**Objection to planning permission Ref. 3/2025/0845
Demolition of Offices and Replacement Office Building
The Village Hall, Franklin Hill, Brockhall Village, Old Langho**

[REDACTED] is instructed by [REDACTED] to object to planning application Ref. 3/2025/0845 by Prometheus Group Service Ltd. The application relates to the former village hall on Franklin Hill Brockhall Village and proposes:

"Demolition of the existing offices and construction of replacement office building".

Drawing Title
Existing Site Plan

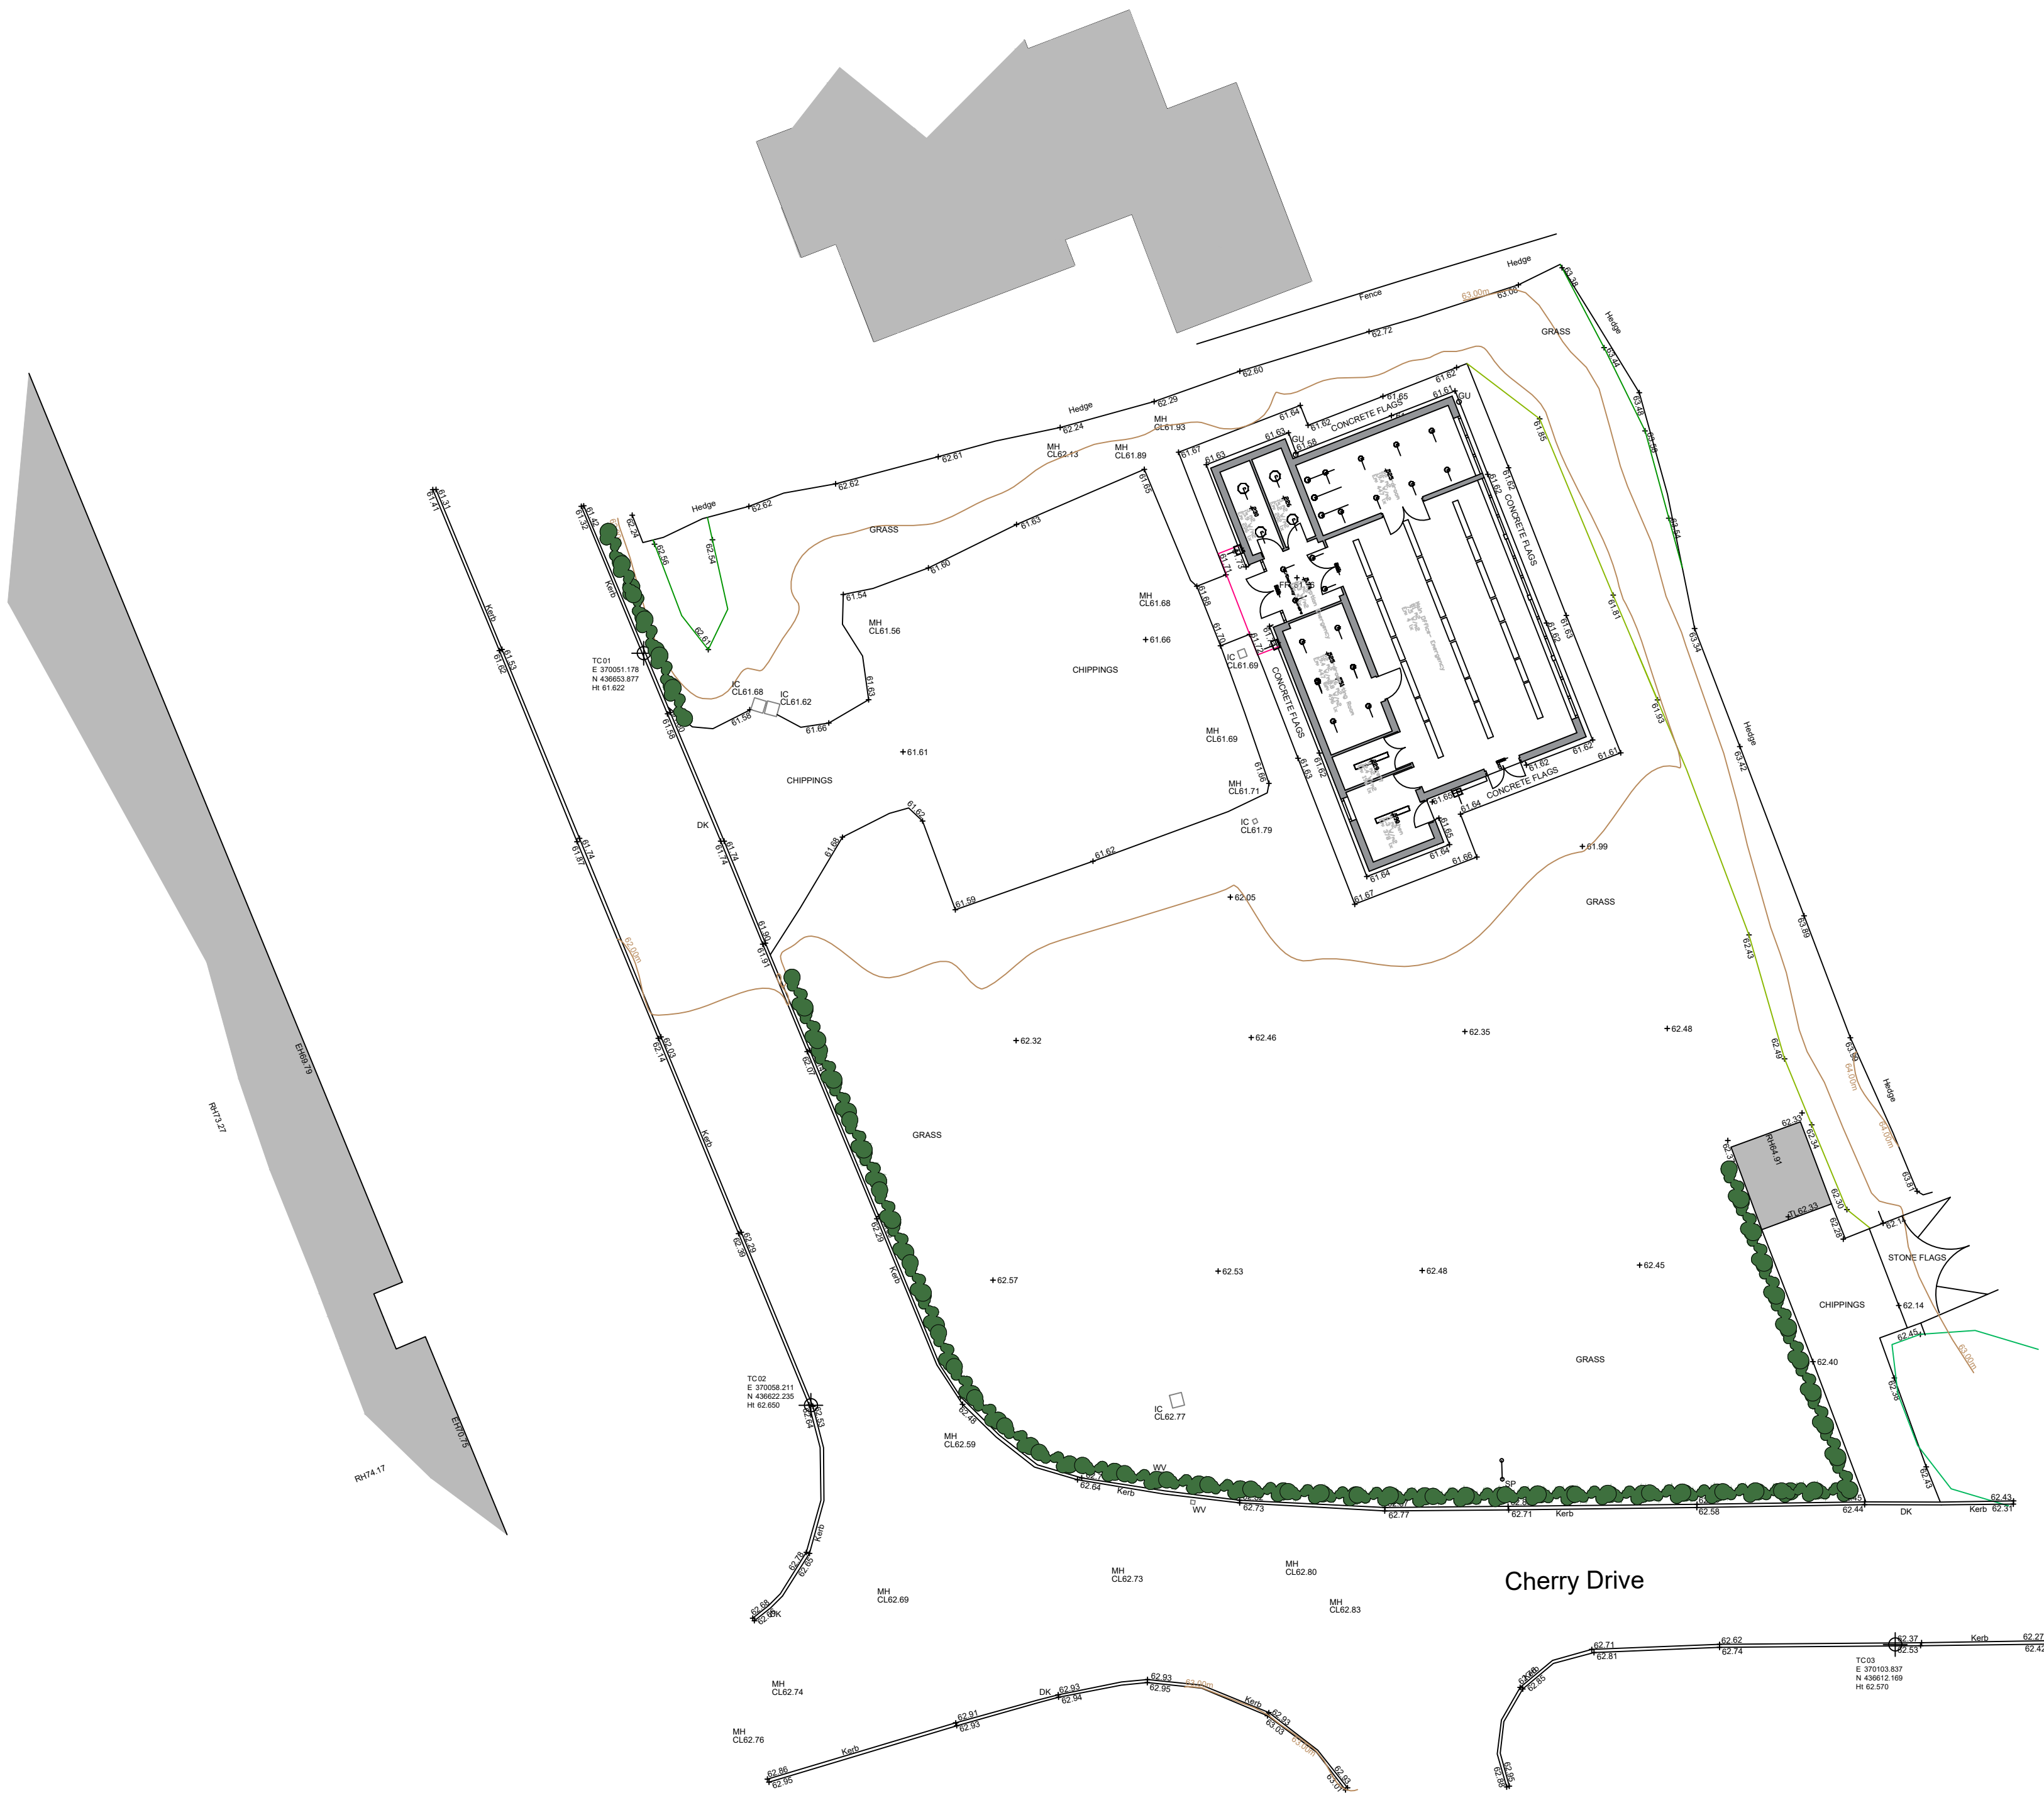
It is also clear from the plans and on site that the applicant is seeking to create and establish one planning unit out of the application site and adjoining public open space. Whilst the site location plan shows the extent of the application site via a red line, this is not detailed on the existing and proposed site layout plan. Indeed, we are not convinced that the extent of the proposed development site can be fully accommodated with the red line as shown on the submitted site location plan and that it may in fact be slightly bigger.

Given the history of this site, the applicant should therefore be required to add the red edge to both the existing and proposed site plans to ensure that the proposed development can indeed be fully accommodated within the application site boundary. The applicant should also be required to define the southern boundary of the site with the open land designated/ public open space to ensure no encroachment of development into this area. This will provide absolute clarity with regards the planning unit and avoid future doubt.

Drawing Title
Proposed Site Plan

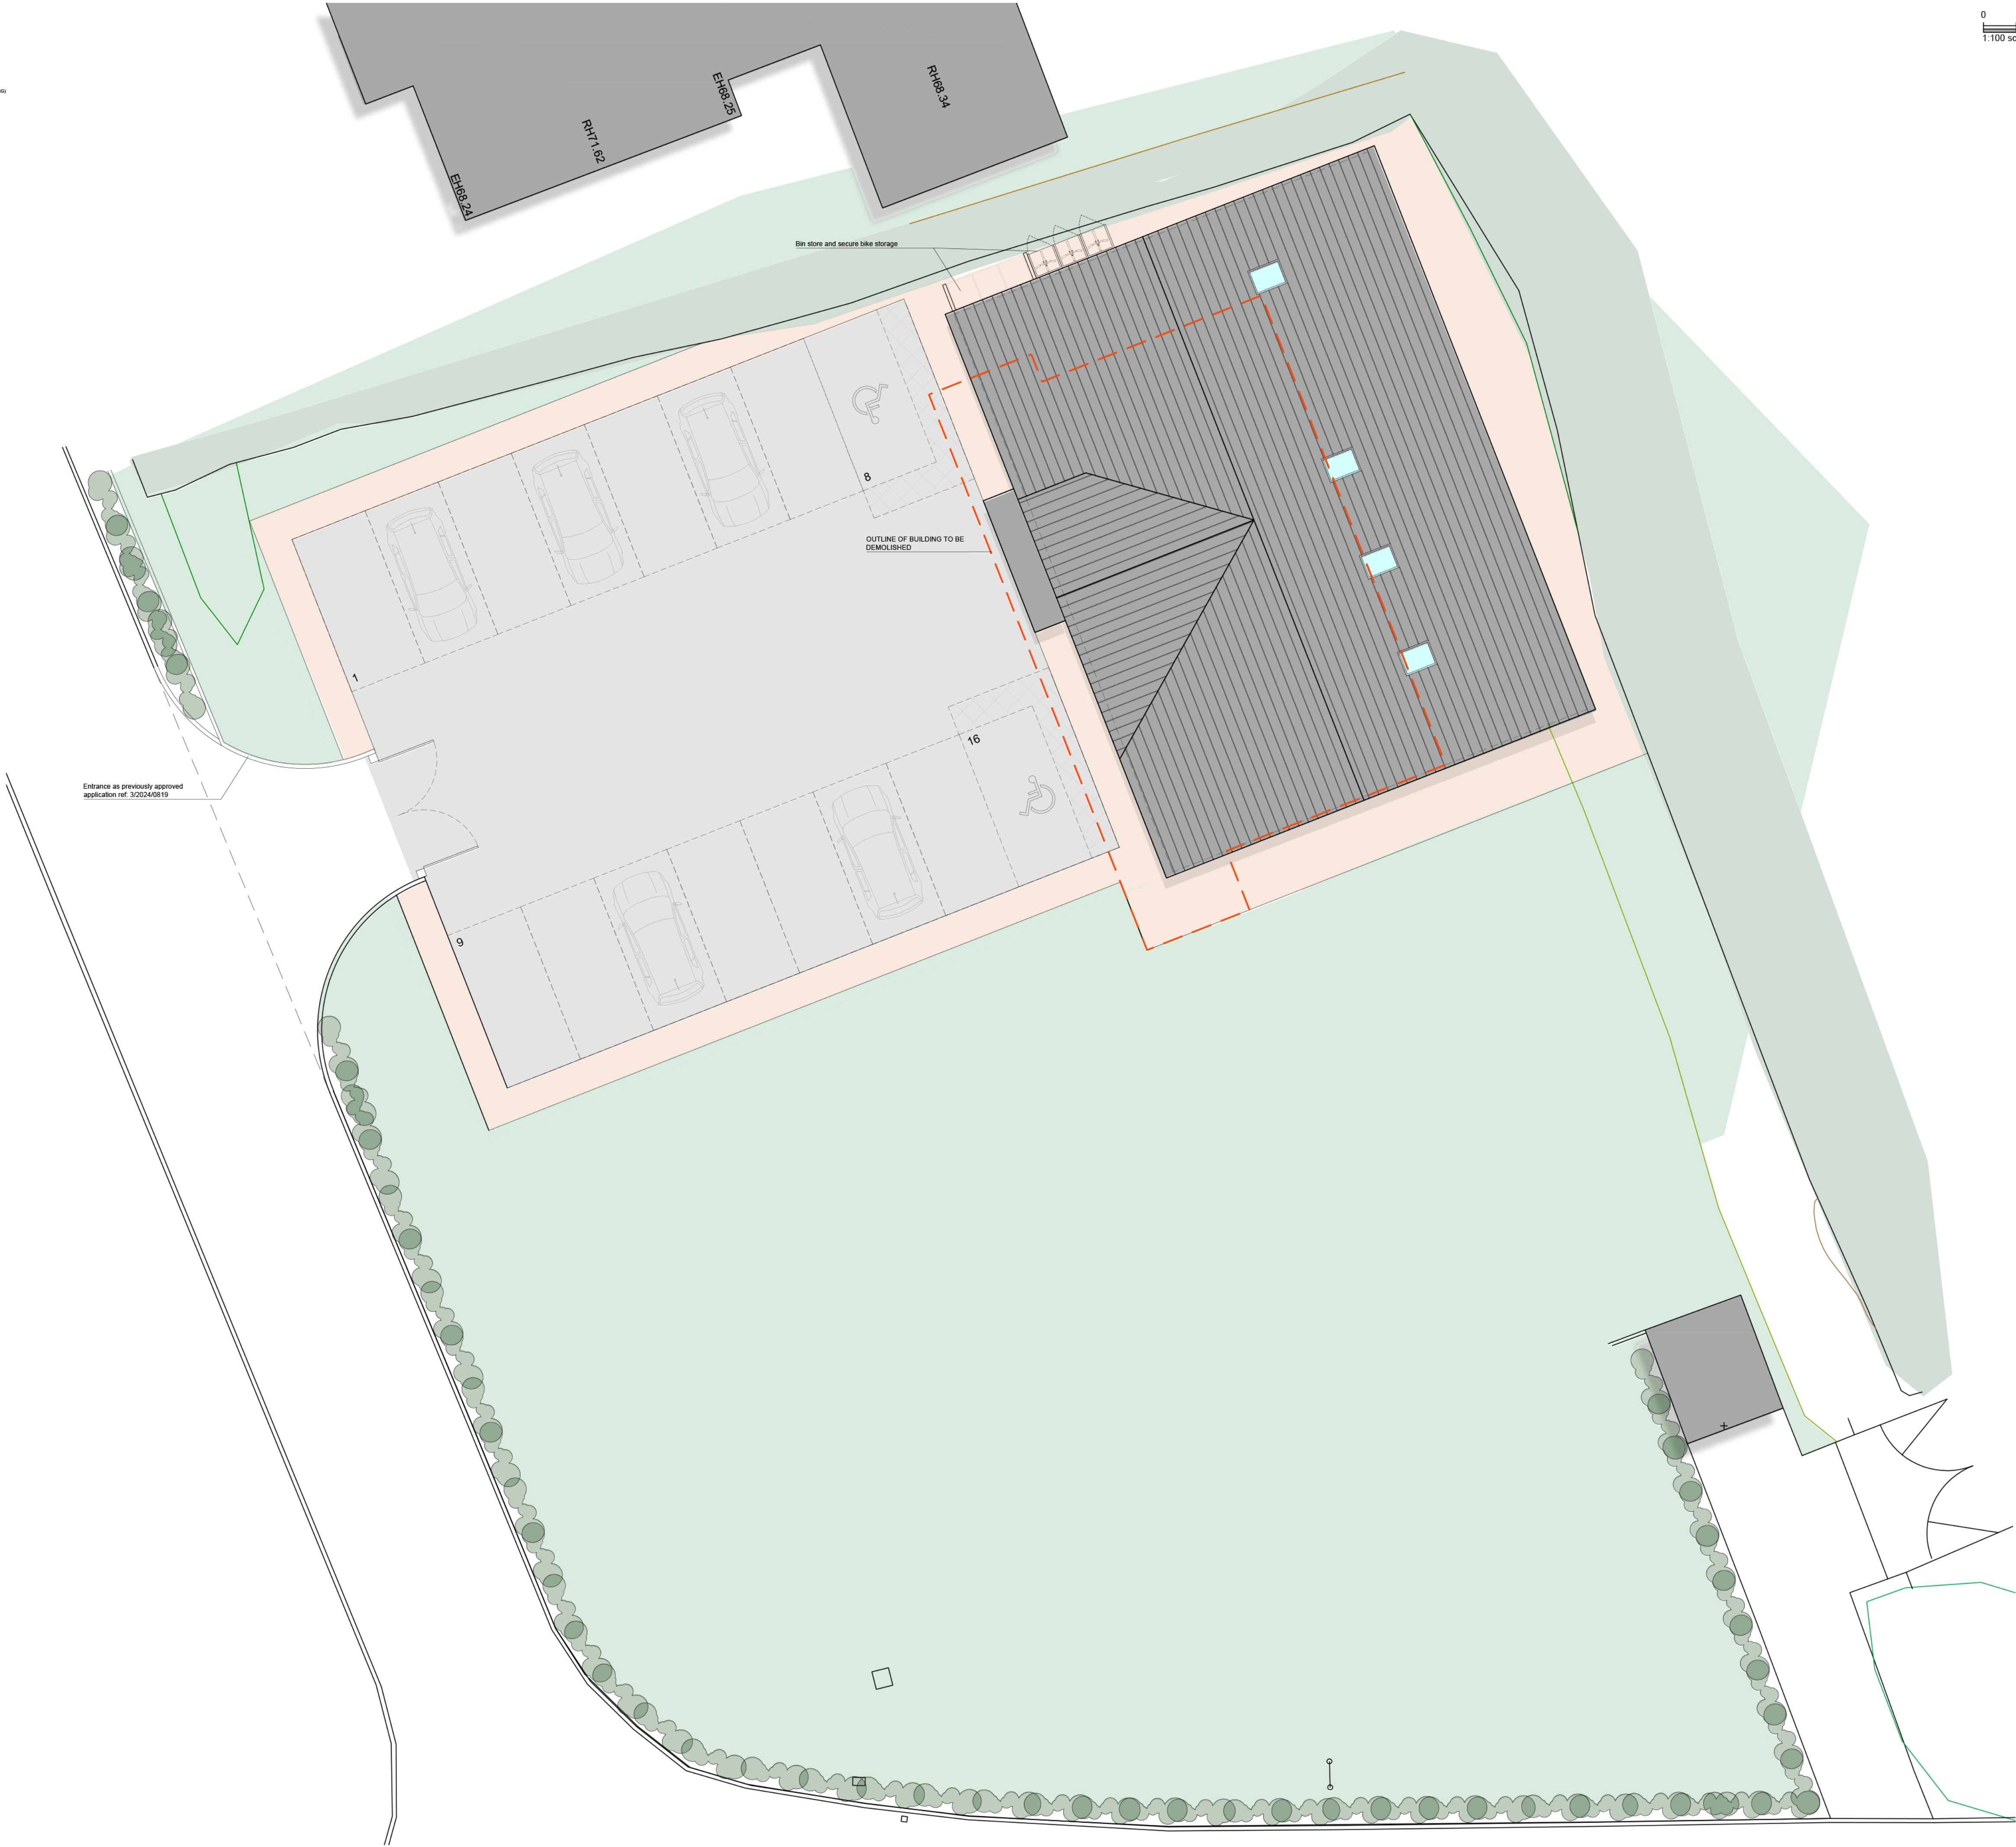
No details are provided of the proposed boundary treatment and given recent enforcement issues and an apparent encroachment into designated public open space, it is respectfully requested that the applicant is required to confirm this on the proposed site layout plan.

We also question whether the proposed development can actually be accommodated within the area of the red line and thus whether the loss of designated public open space is thus even greater.
